DOC18/435192-07; EF13/2545

**Proposed Modification to Dartbrook Coal Mine, Modification 7 (DA 231-07-2000)
Bord and Pillar Extraction and Extension Modification
Recommended Conditions**

The EPA has reviewed the modification application, and supporting documentation titled "*Dartbrook Mine- Modification 7- Environmental Assessment for Australian Pacific Coal Limited. June 2018.*"

Figure 9: Receiver Zones and Locations

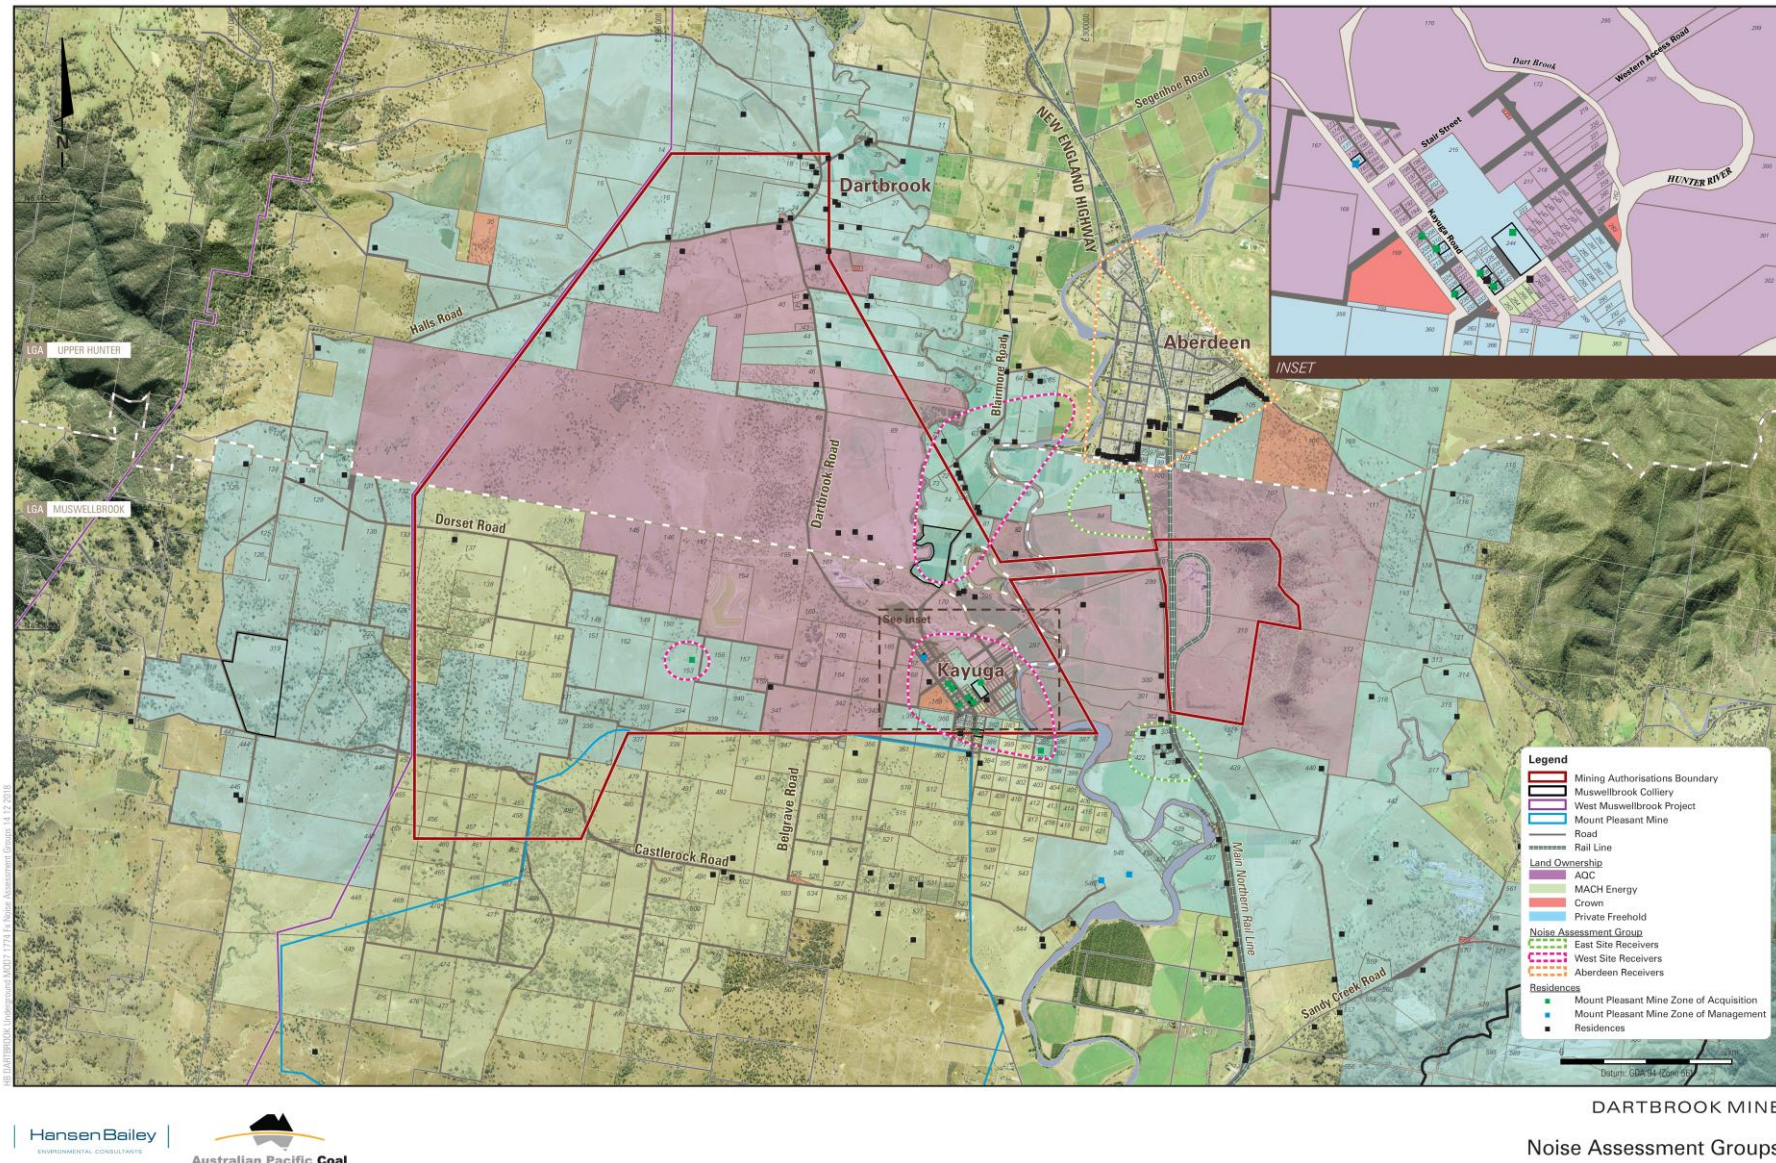
- 1) The EPA notes that receiver locations are taken from Schedules A and B of the Dartbrook consolidated project consent (N99/00230 dated 28 August 2001). The Lot and DP numbers for the receiver identifications need to be provided.
